Application no: H19/0625/03
Original Applicant: Mr S R Ward
The Bungalow
Luttongate Road
Gedney Hill
Spalding Lincs

Description: Proposed agricultural bungalow

Location: Opposite 'Westwards'
Luttongate Road
Gedney Hill

Amendment: Change from brown hardwood windows to brown
UPVC windows

MATERIALS

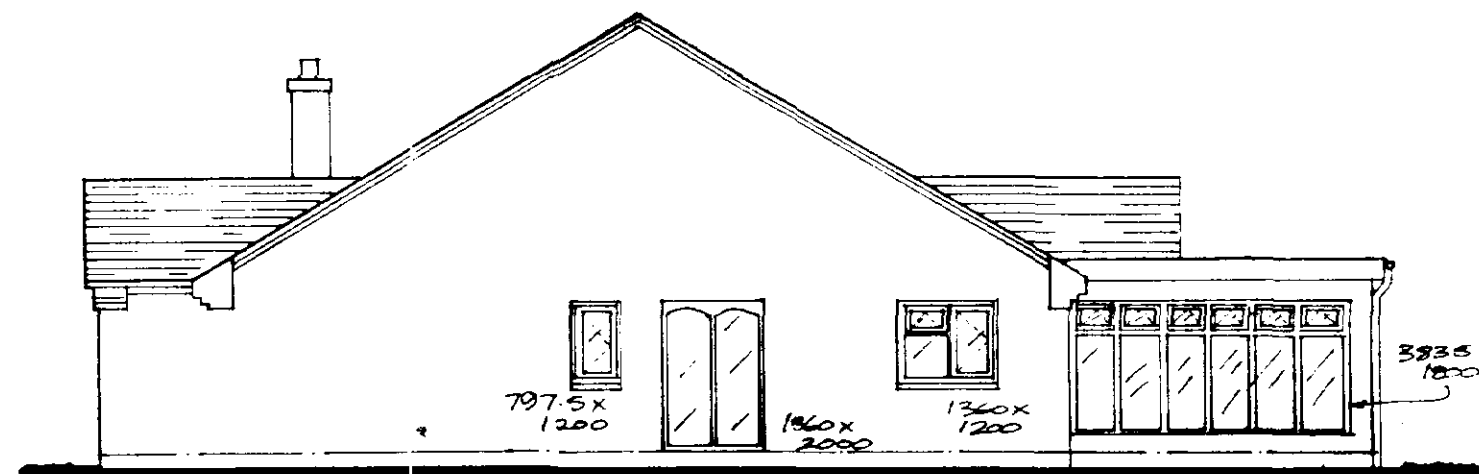
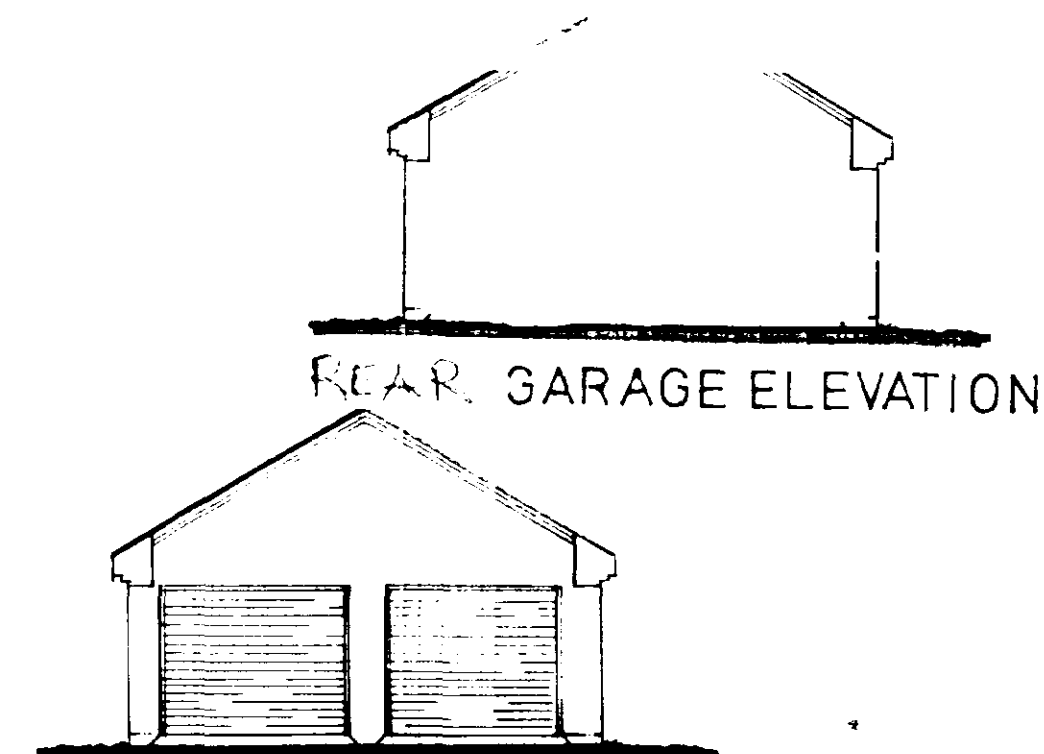
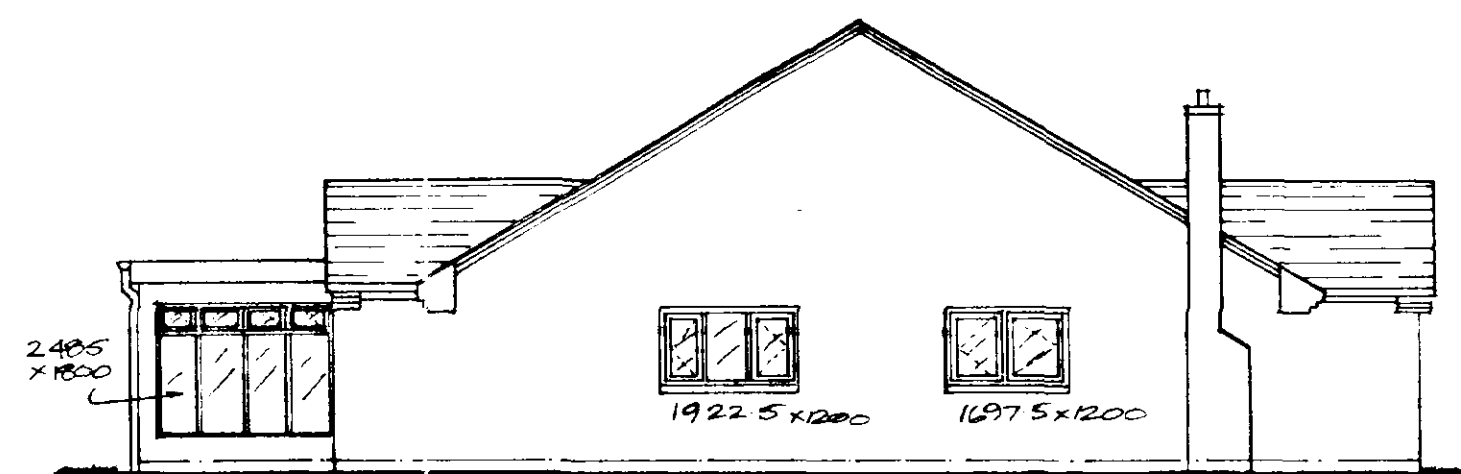
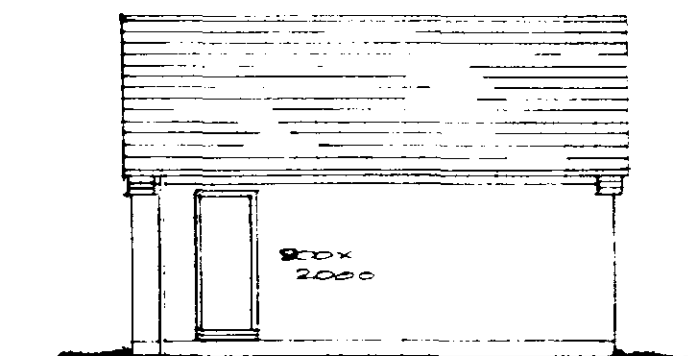
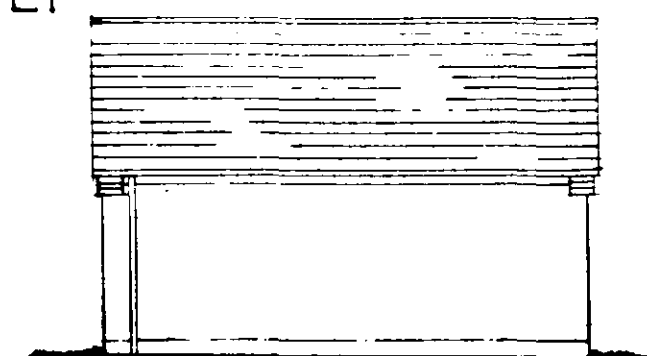
**CHANGING FROM BROWN
HARDWOOD WINDOWS
TO BROWN PLASTIC**

The amended details submitted in respect of the above proposal have now been considered and there are no objections to the amendment being implemented to the extent described above.
